From: Mark Peacock
Sent: 03 May 2012 13:49
To: Planning
Subject: FW: 33 Kentish Lane Brookmans Pk 2012/479
Attachments: Consultants list 2012.xls

Consultation response from HBRC

S6/2012/0479/FP – 33 Kentish Lane (Erection of new dwelling following demolition of existing).

Existing Elevations

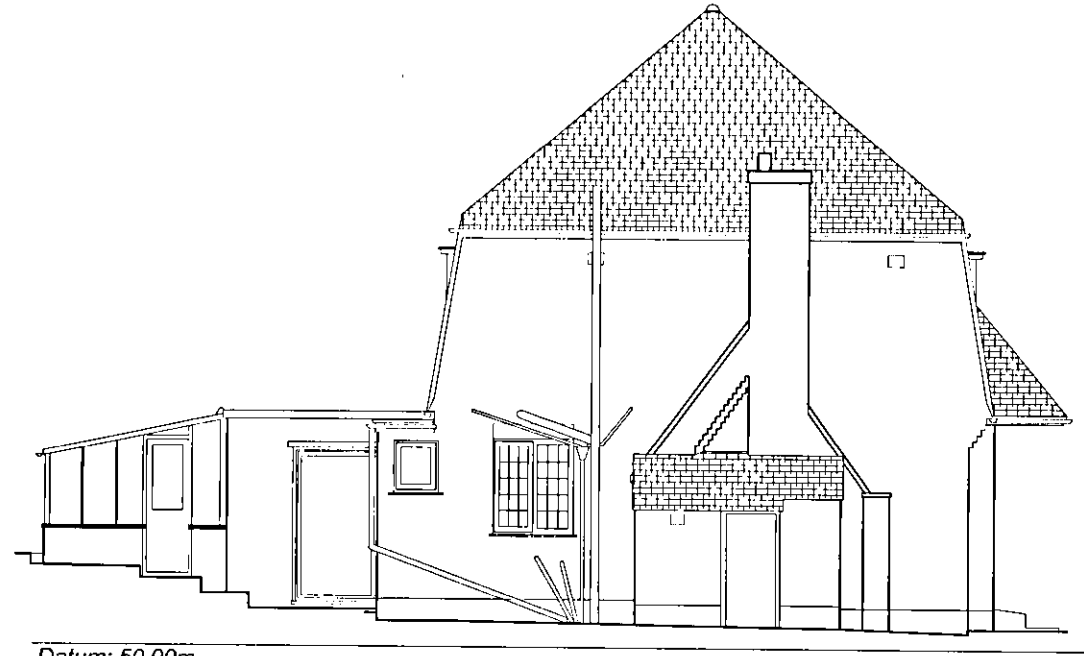
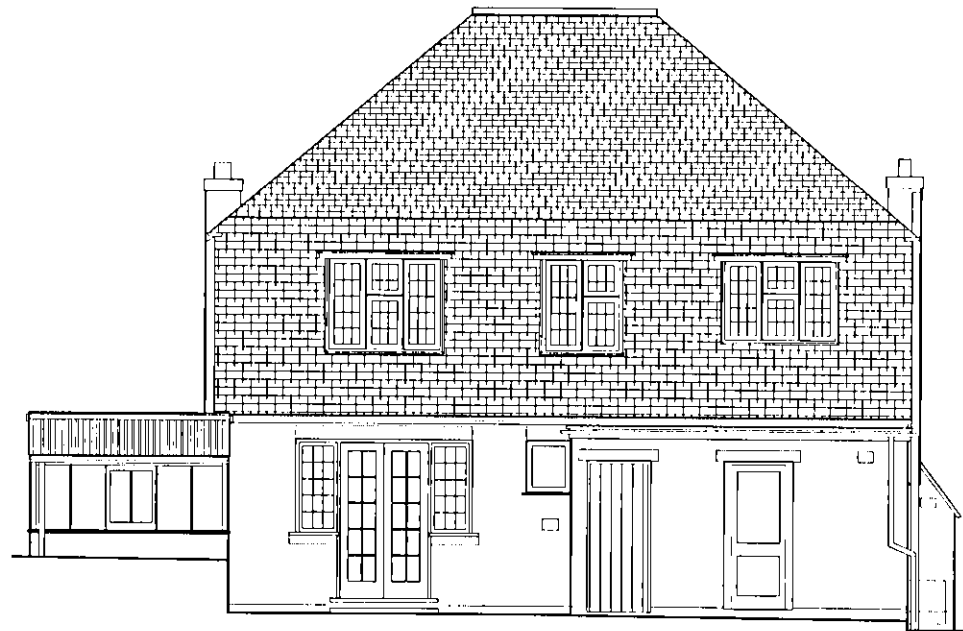
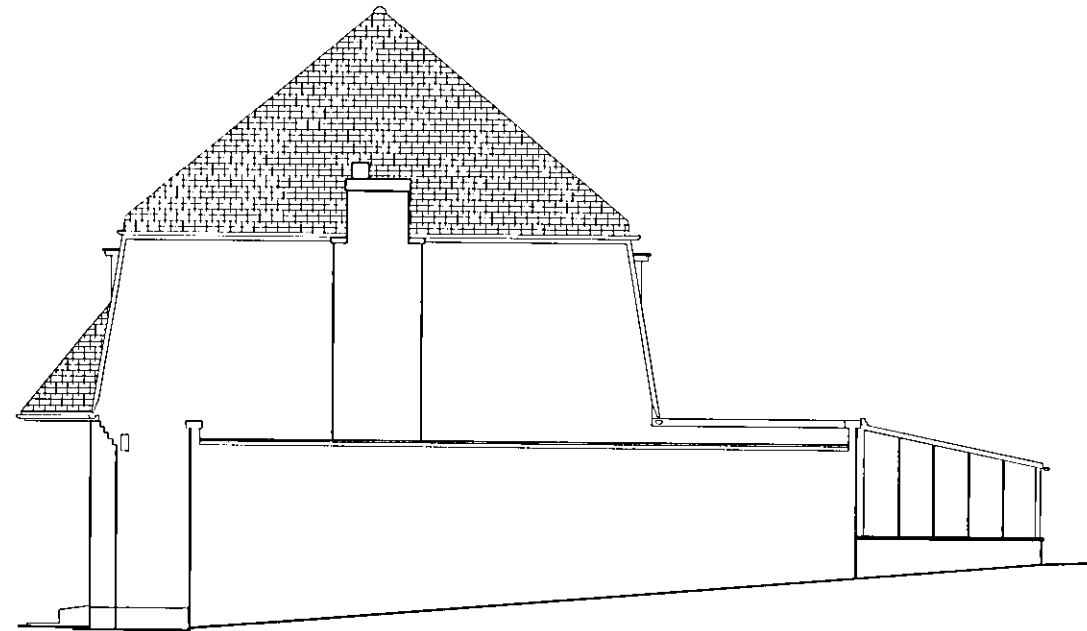
1. There are bat records in the area and the house is located within a well-treed environment, providing foraging and flight-line habitats. There is currently an empty (otherwise unconverted) roofspace and the front and back upper storey appears externally covered with hanging tiles. All of these indicate there is a considerable potential for bats to be present and obviously affected if the property is to be demolished.

2. I therefore advise that an inspection survey for bats should be undertaken to assess the position. I am not clear from you e-mail whether a bat survey has been undertaken for this application but there isn't one on the documents list within the Dataspace electronic consultation. This should be undertaken before the application is fully approved otherwise the provisions of the Habitats Directive would not have been followed. Further surveys may be necessary depending on the results, although if bats are not an issue the application may be determined accordingly. I have attached a list of consultants who may be of assistance with this.
